PCD FILE NO. PPR-21-033

PLANNING NOTE: This review is for the Variance of Use request. Additional comments will be made during implementation of a Site Development Plan, which follows the Variance request.

GATEWAY TRUCKING SITE DEVELOPMENT PLAN	
SITE DEVELOPMENT PLAN	
SHEET	1 OF 2
JOB NO.	25215.00

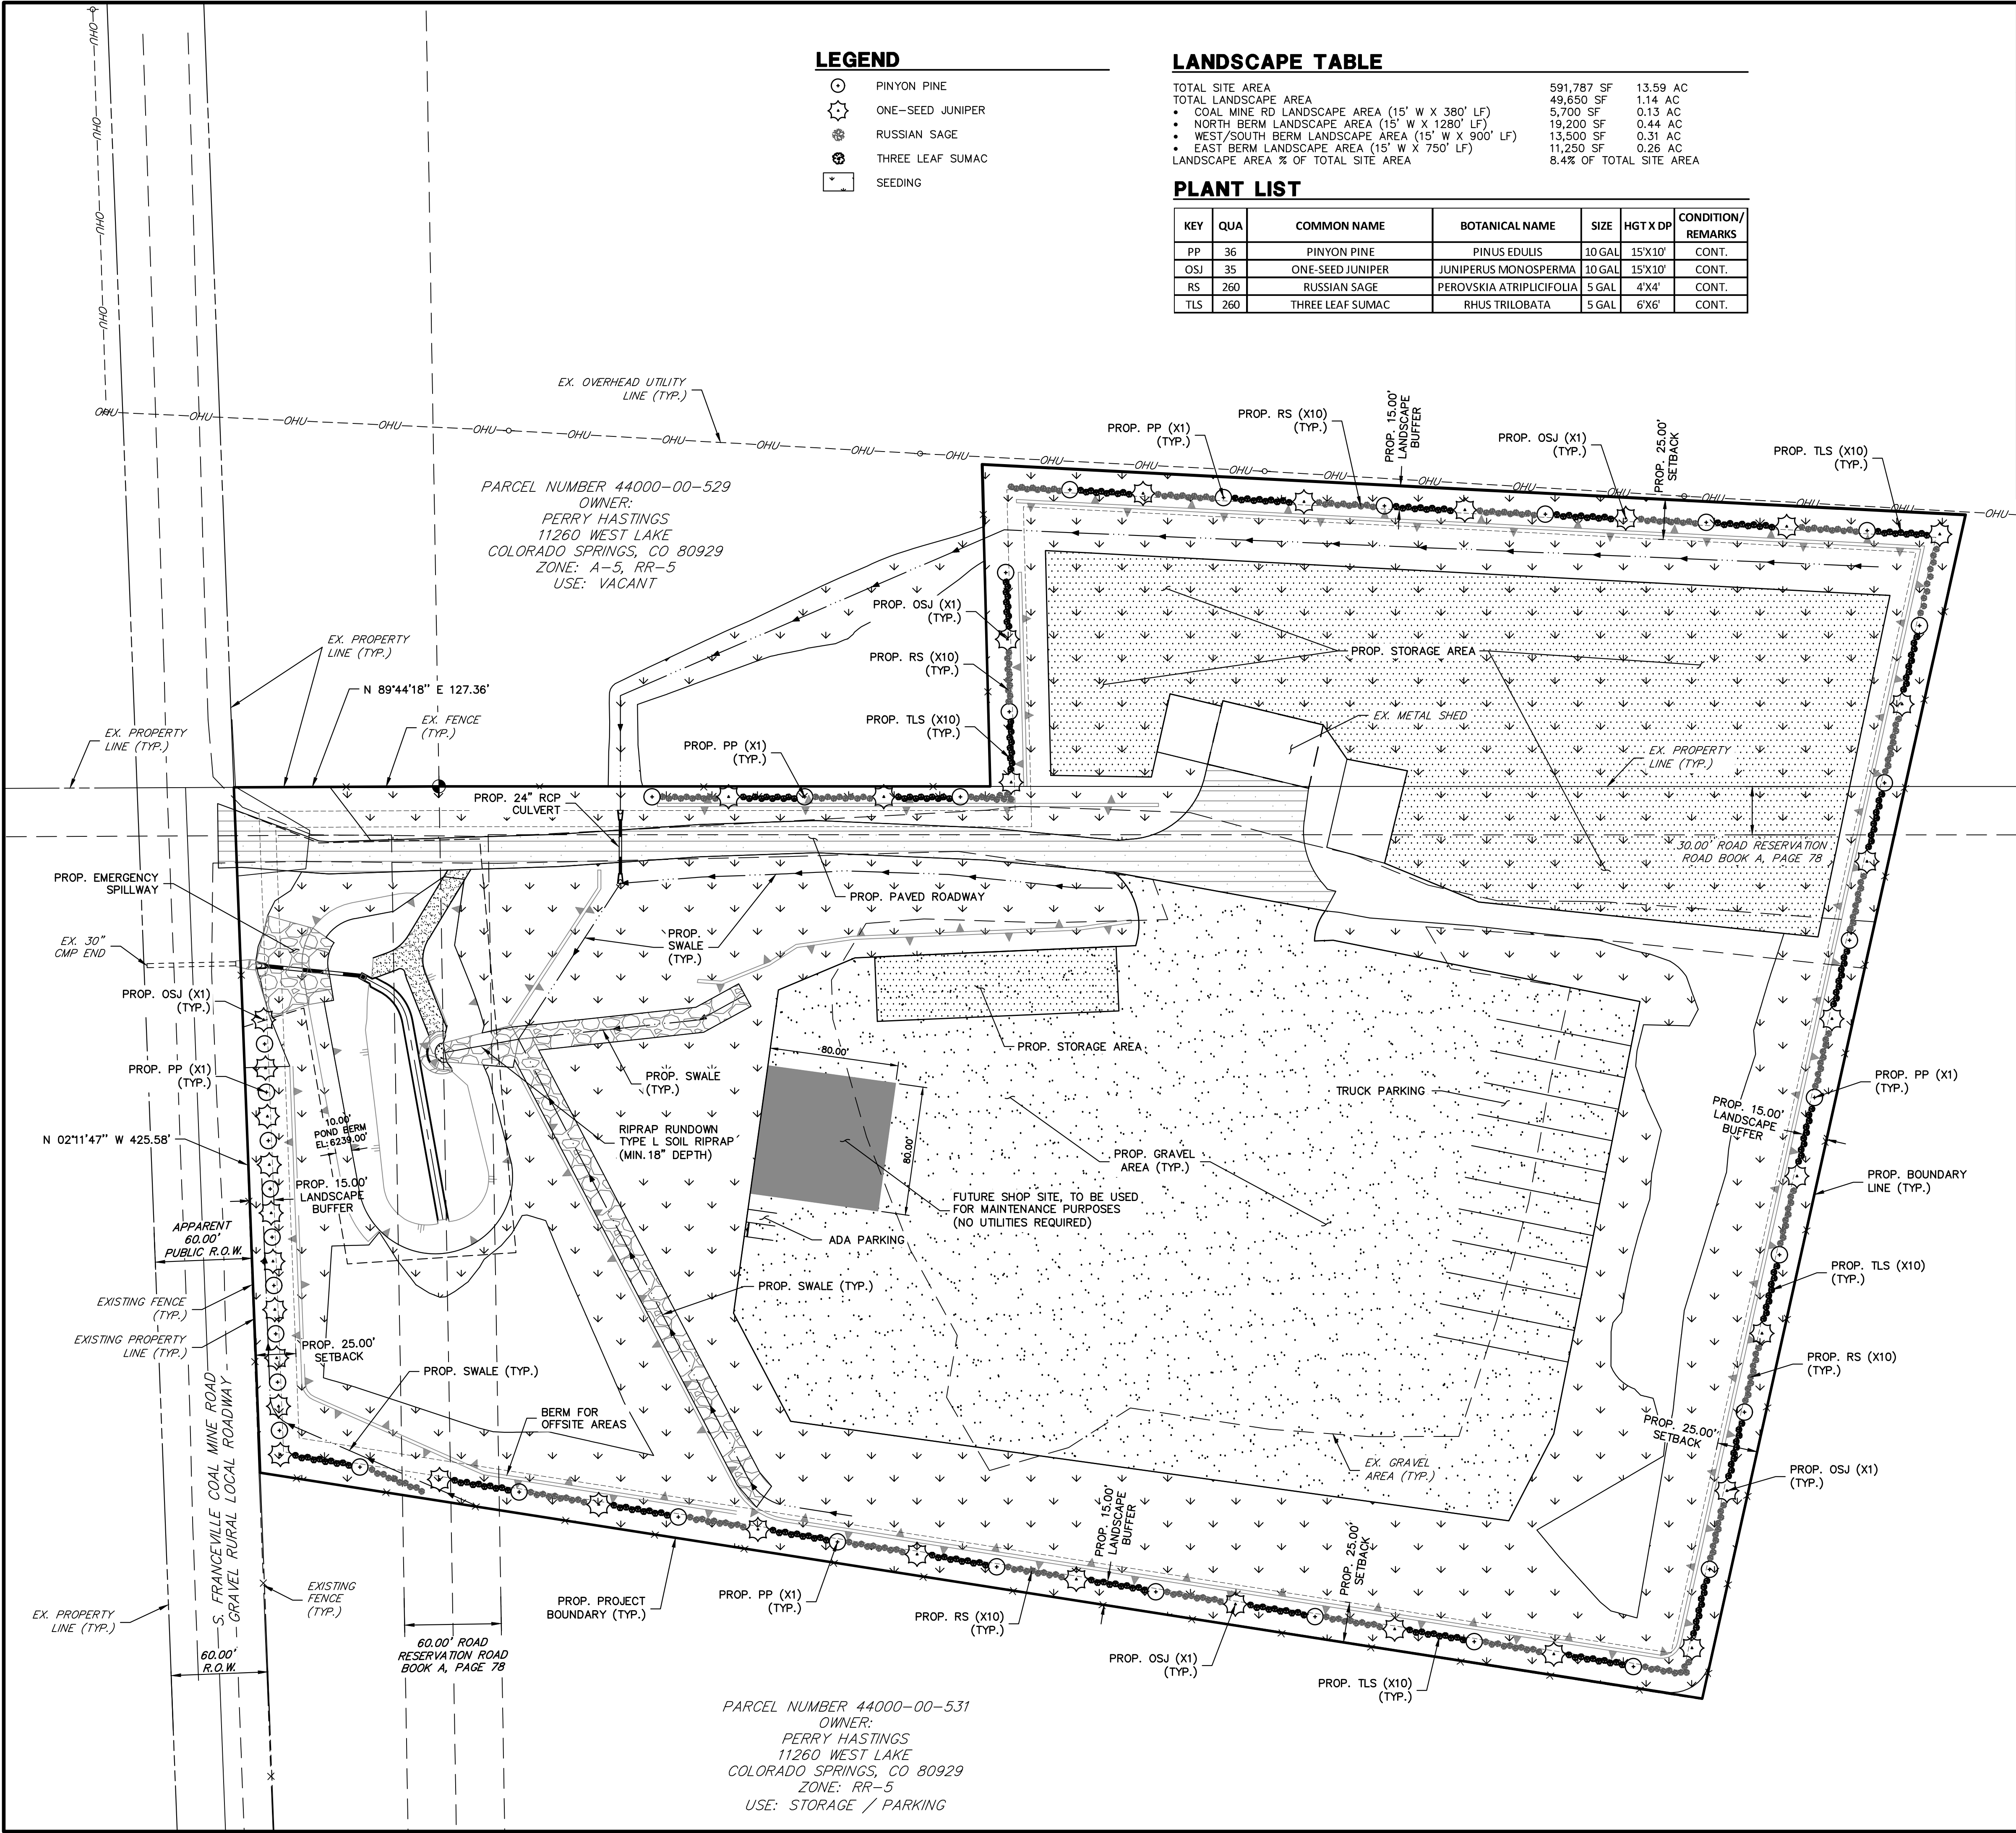
Provide the Reception Number of this Easement. Also identify the width of the Easement.

The letter of intent stated that materials were not hauled to or stored on site. These areas do not appear to be truck/trailer/commercial equipment? Describe the purpose of this storage area.

Add soft of these storage areas

Identify the sight distance length per ECM

This central area appears to be used as parking and storage as well. Please show this on the site plan and include this in your calculations and discussion.

FUTURE SHOP SITE
Provide dimensions and purpose of shop.

Only 27 identified parking spaces would not accommodate what is currently parked/stored on the property. Please adjust as needed.

DEVELOPMENT TIME TABLE:
SUMMER 2025
Commercial vehicle storage, most like Code's "Contractor's Equipment Yard". ALSO, address the proposed building. The previous site plan showed 30 employee parking spaces. Is that no longer needed?

8.00' (TYP.)
Minimum width is 9.00'
JR Response: Addressed

Structures may not encroach into the setbacks.

JR Response: Still working on tracking down this information.

JR Response: In notes indicated the storage area is for equipment storage only, no waste disposal or storage of rubbish.

JR Response: Addressed.

JR Response: Addressed

JR Response: Reduced the number of parking spaces to 10 and we are requesting an alternative parking ratio.

JR Response: Provided dimensions and purpose.

JR Response: Addressed

JR Response: Reduced the number of parking spaces to 10 and we are requesting an alternative parking ratio.

JR Response: Using the guidance from EPC, we will be pursuing a site boundary change.
